From: [REDACTED]
Sent: 04 October 2018 14:40
To: Anita Gardner
Subject: Re: R/152/18/DOC - Landscaping condition - 2 Broadmark Lane, Rustington

I have today received the comments of the Landscape Officer. She has stated 'The information submitted in dwg 15/1091/02 rev C has not been supplied in sufficient detail. The landscape planting detail needs to be included in plan form with species choice and actual proposed plant numbers, densities and height at time of planting. The drawings submitted at present are lacking this detail.'

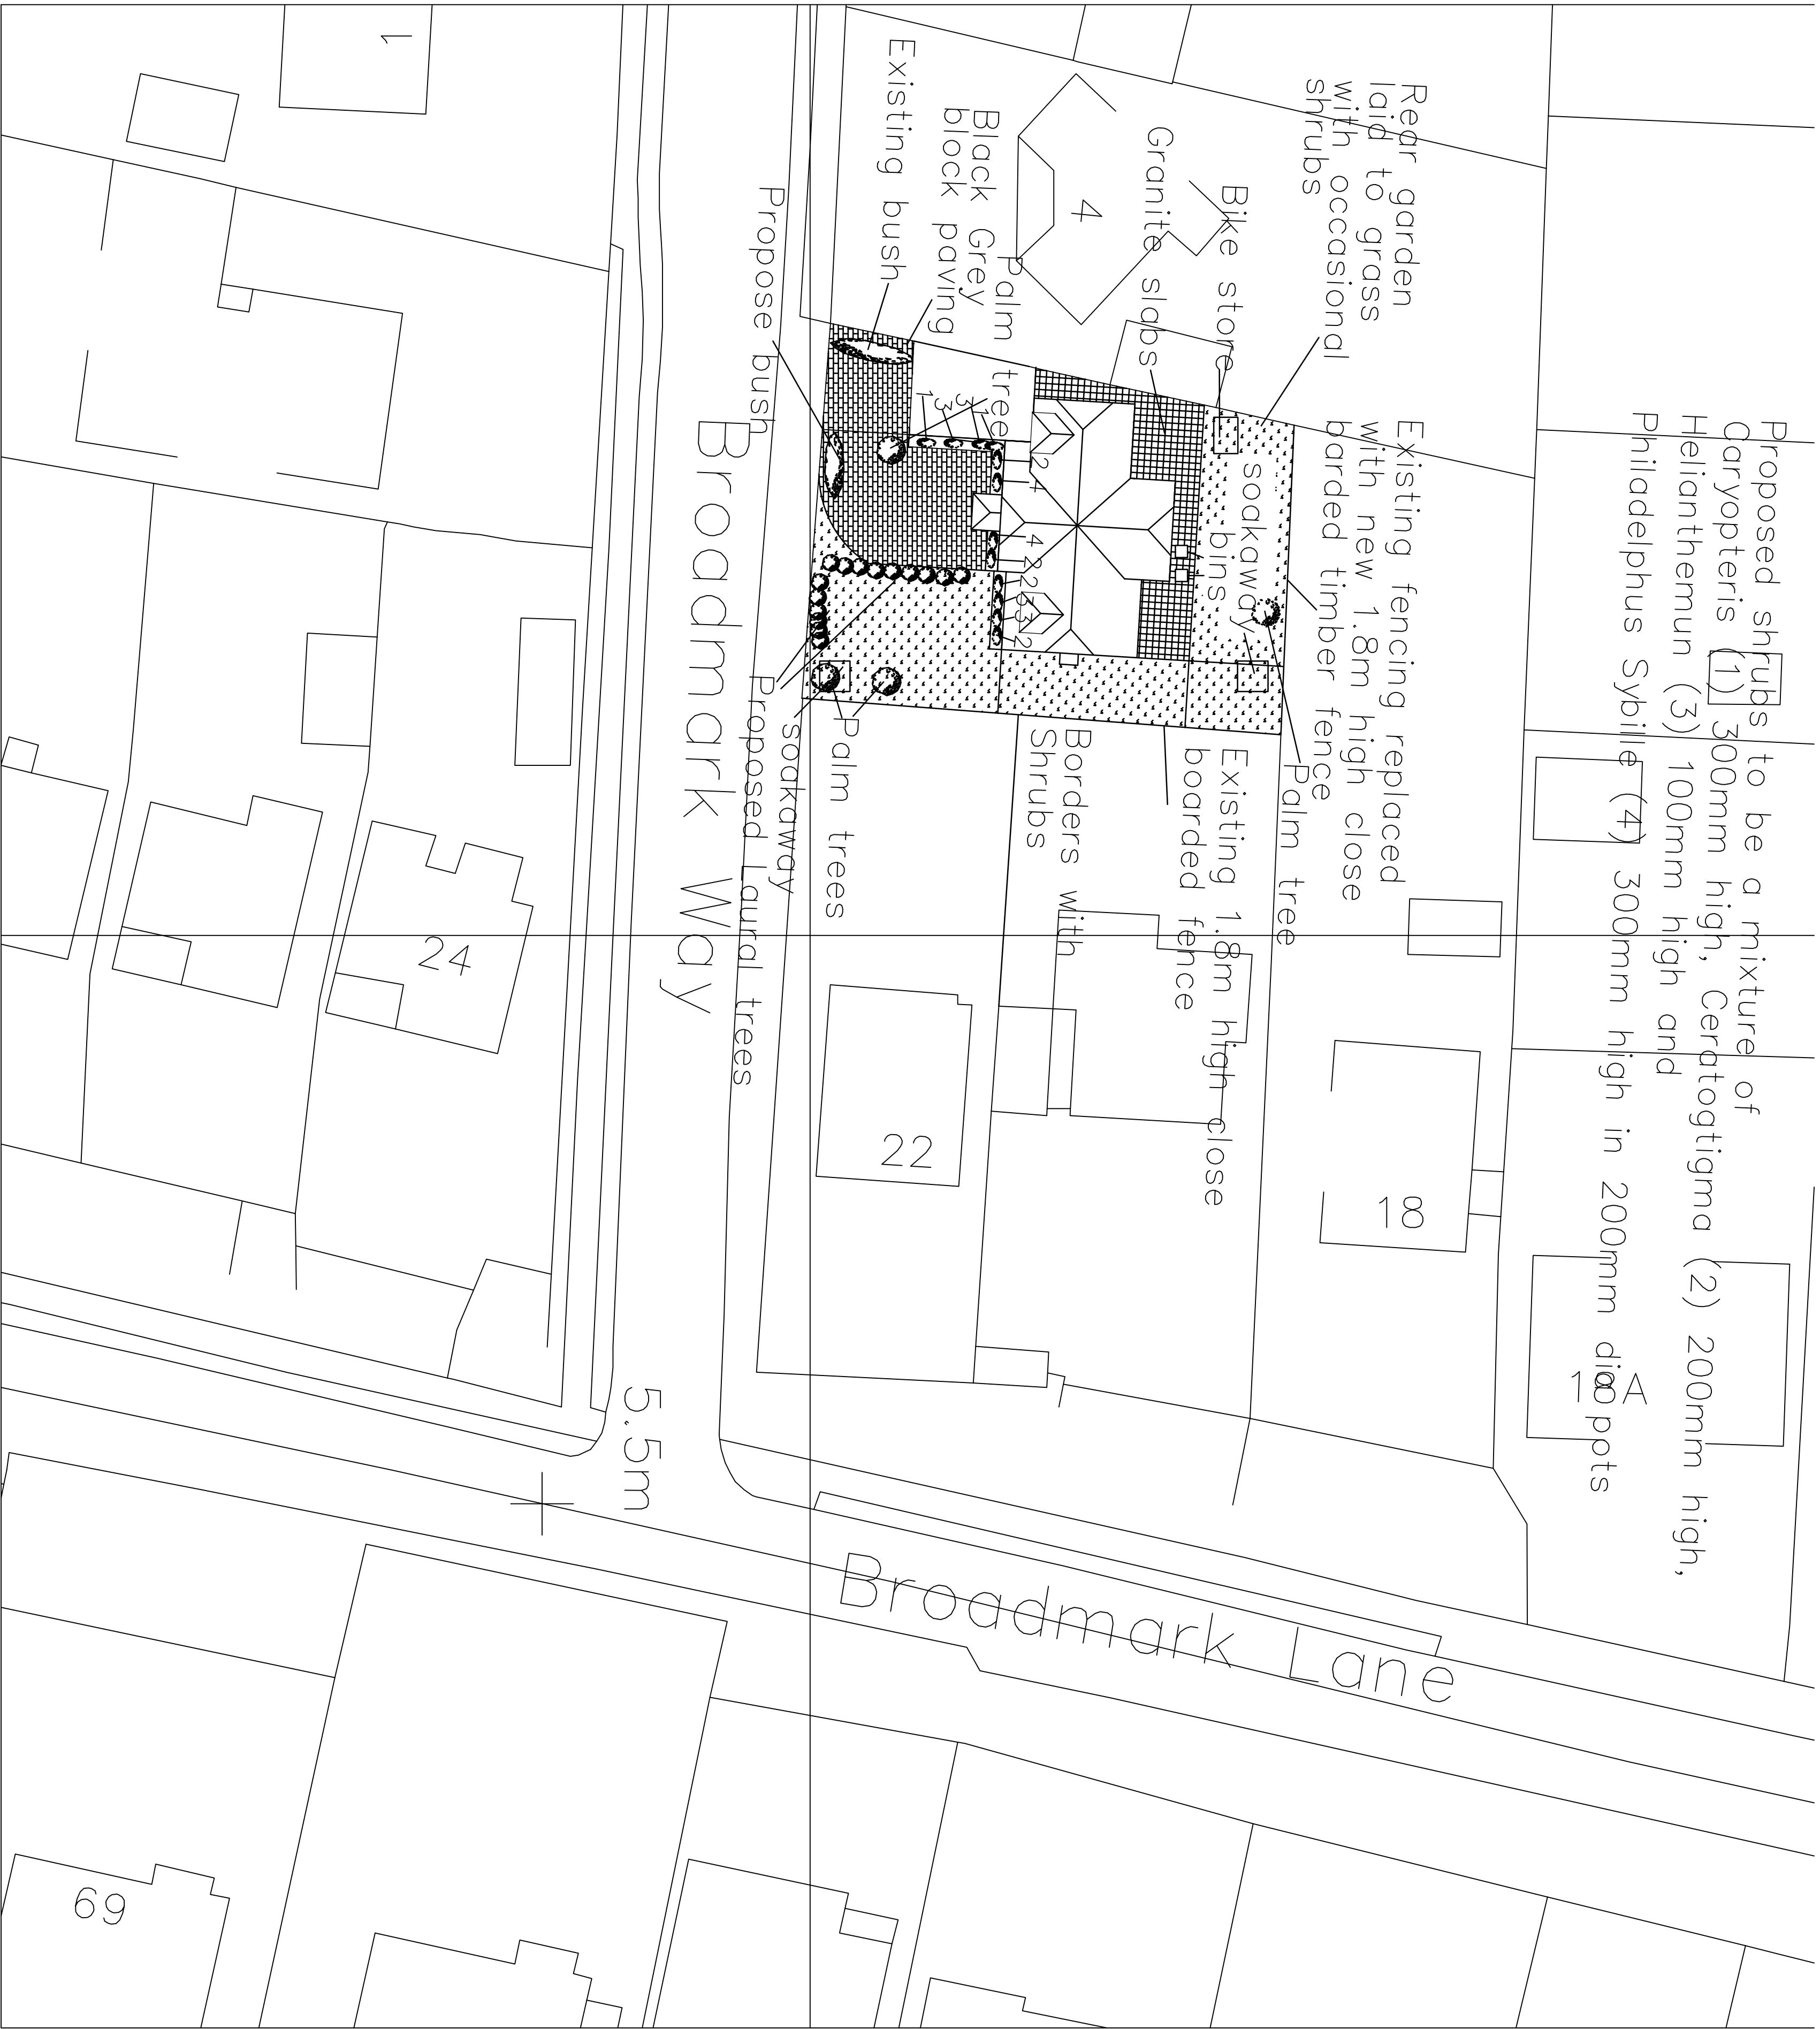
Dear Tony,
Thank you. Can you also confirm the species and size of the proposed bush indicated in the front garden?
Anita

What about the size of the palm trees, the number and size of laurels on the site frontage and the bush on the site frontage? Can these details be confirmed please? They don't need to be indicated on plan, but I would appreciate conformation by e-mail which can then be added to the application.

It will be as existing.

The palm trees will be 900mm high, the laurels 900mm high as for the hedging.
